ECOLOGICAL ADVICE SERVICE

SUBJECT: *SE/19/05000/HYB / Fort Halstead, Halstead*

In response, an updated 'Framework Ecological Mitigation Strategy' (FEMS), along with a LEMP, have been provided which addresses our original concerns regarding ecology.

TITLE  
**PROPOSED EXTERNAL ISOLINE CONTOURS FOR ARTIFICIAL LIGHTING**

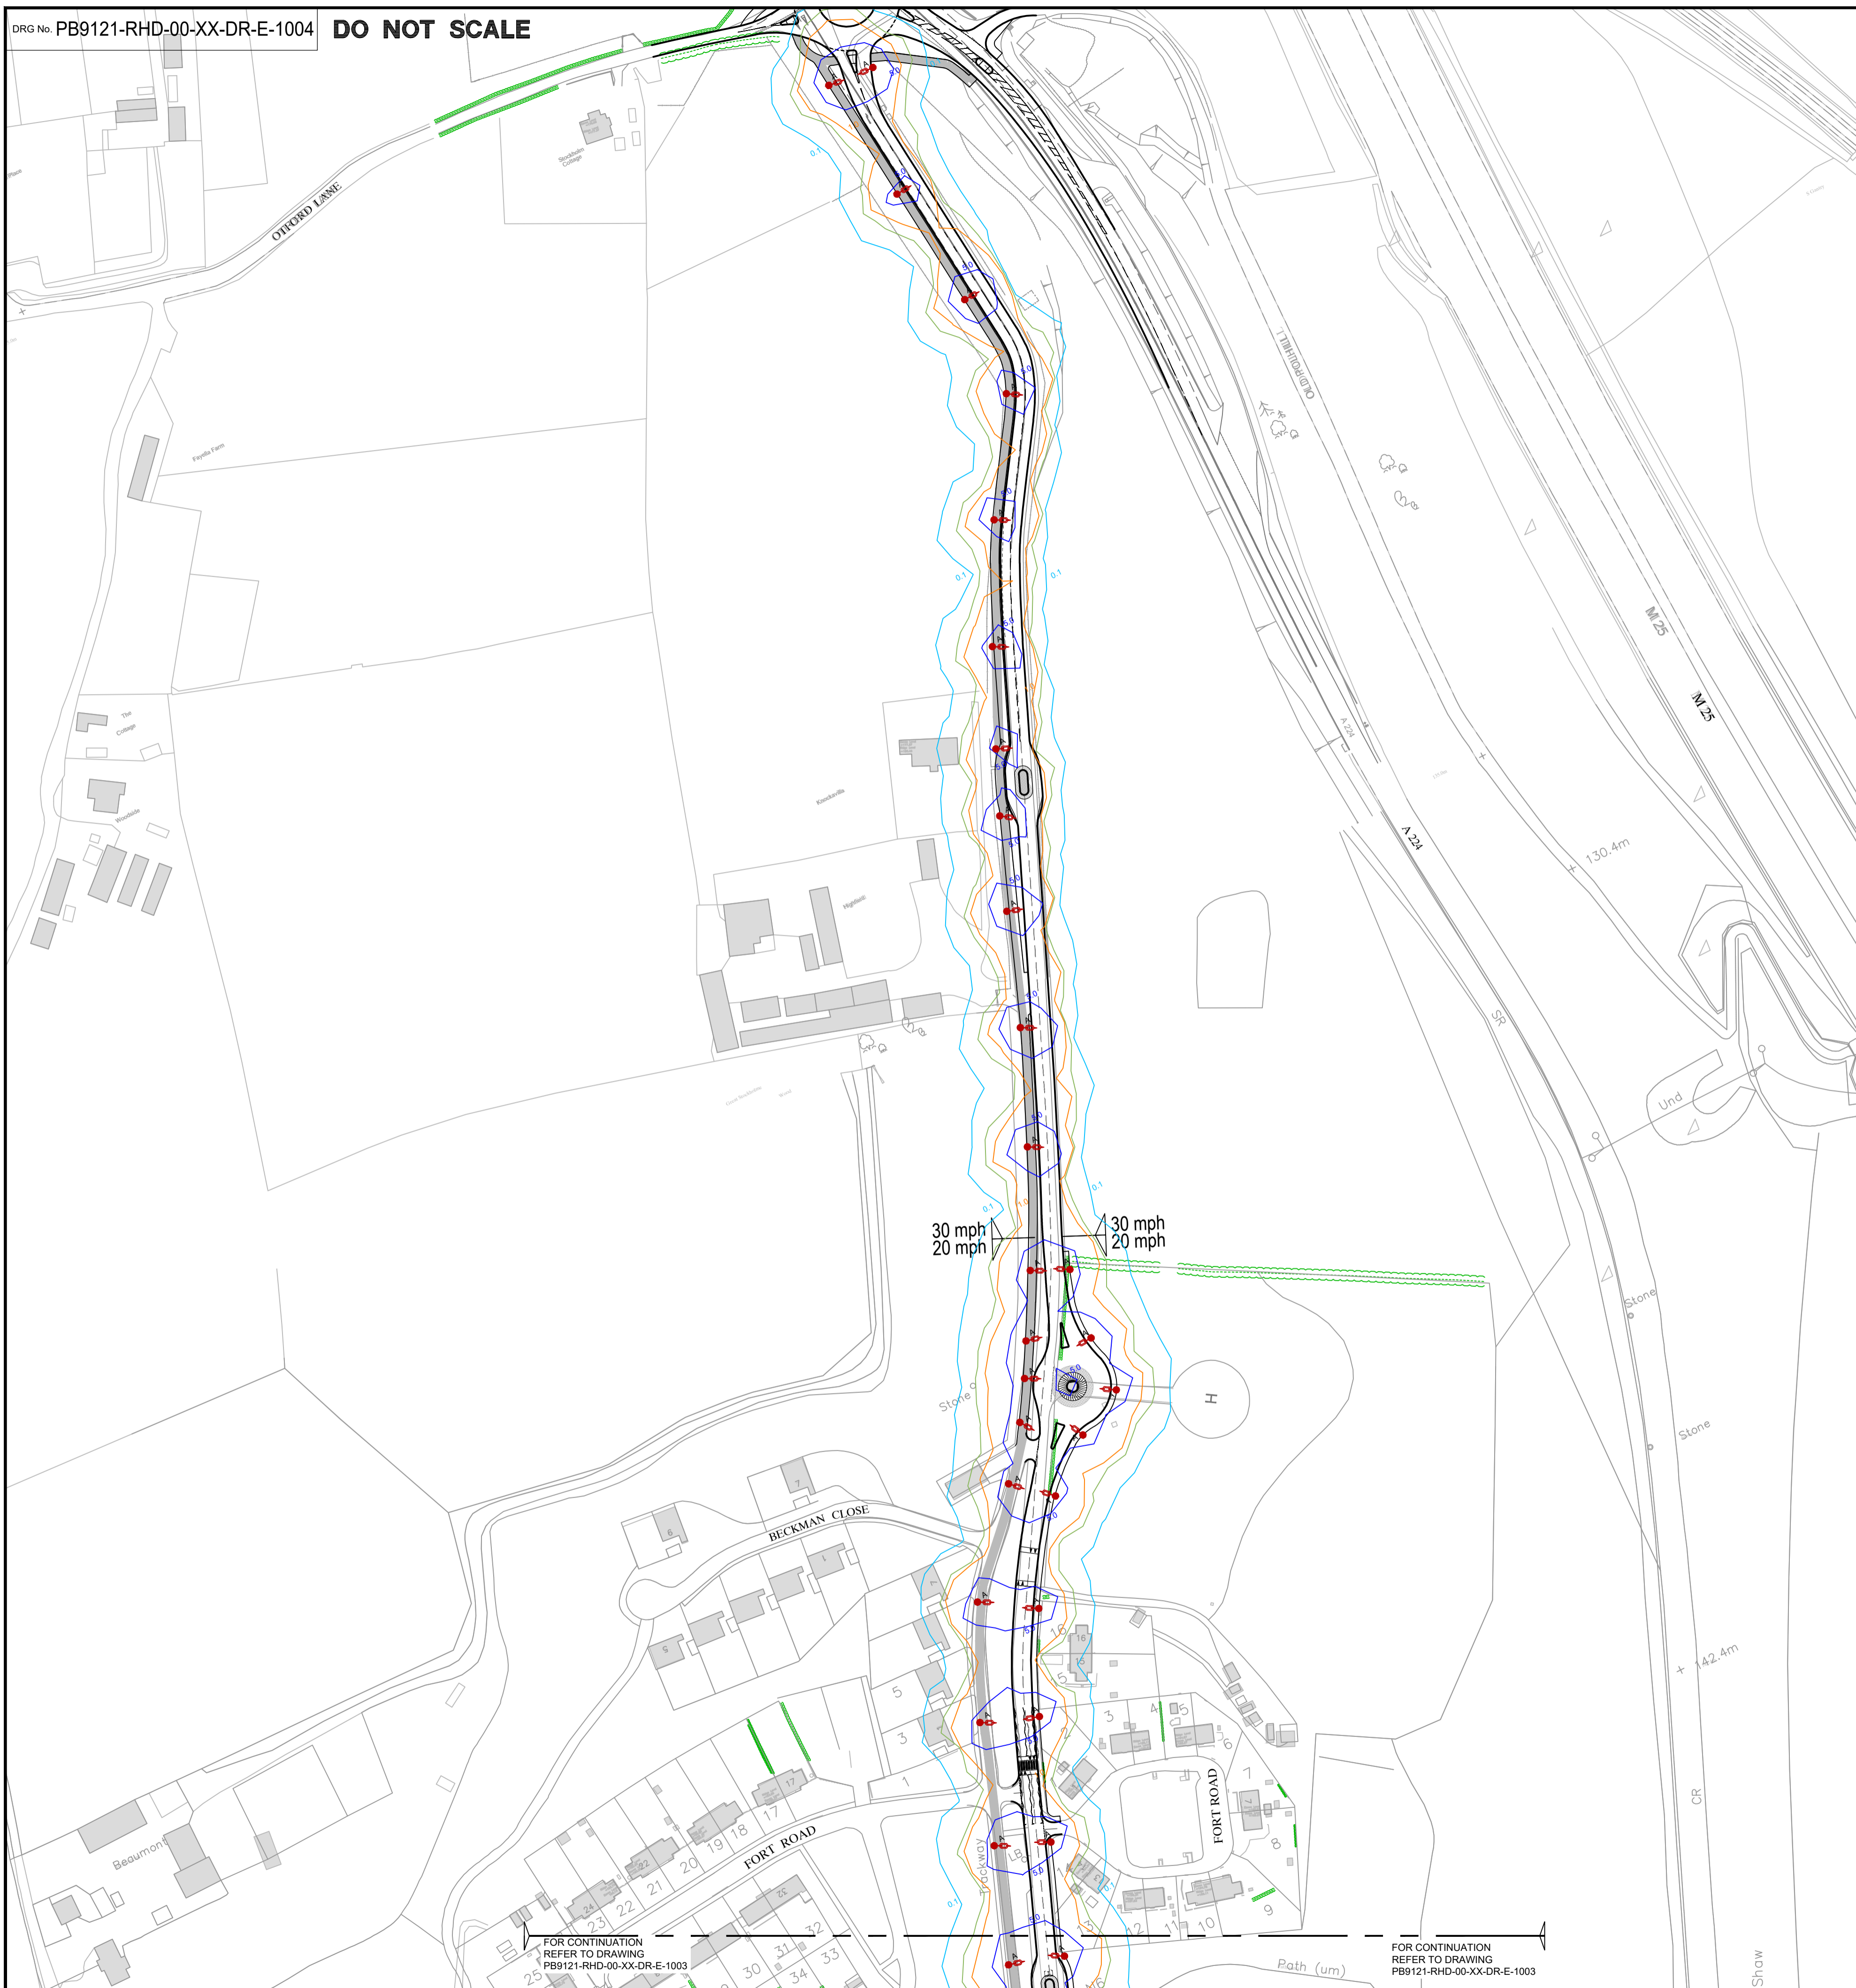
Further information has been provided regarding the development's external lighting impact. A map has been provided within the 'Summary Lighting Assessment', clearly showing expected positioning of external lighting, and associated light spill in lux levels. Efforts have been made to limit light spill and it is stated all lighting installation will comply with the respective Sevenoaks lighting policies. Additionally, as proposed within the bat mitigation details (and secured via Natural England licence), there will be no direct lighting on replacement bat roosts.

We are satisfied that the outline strategy for lighting is appropriate and can be secured via an attached condition.
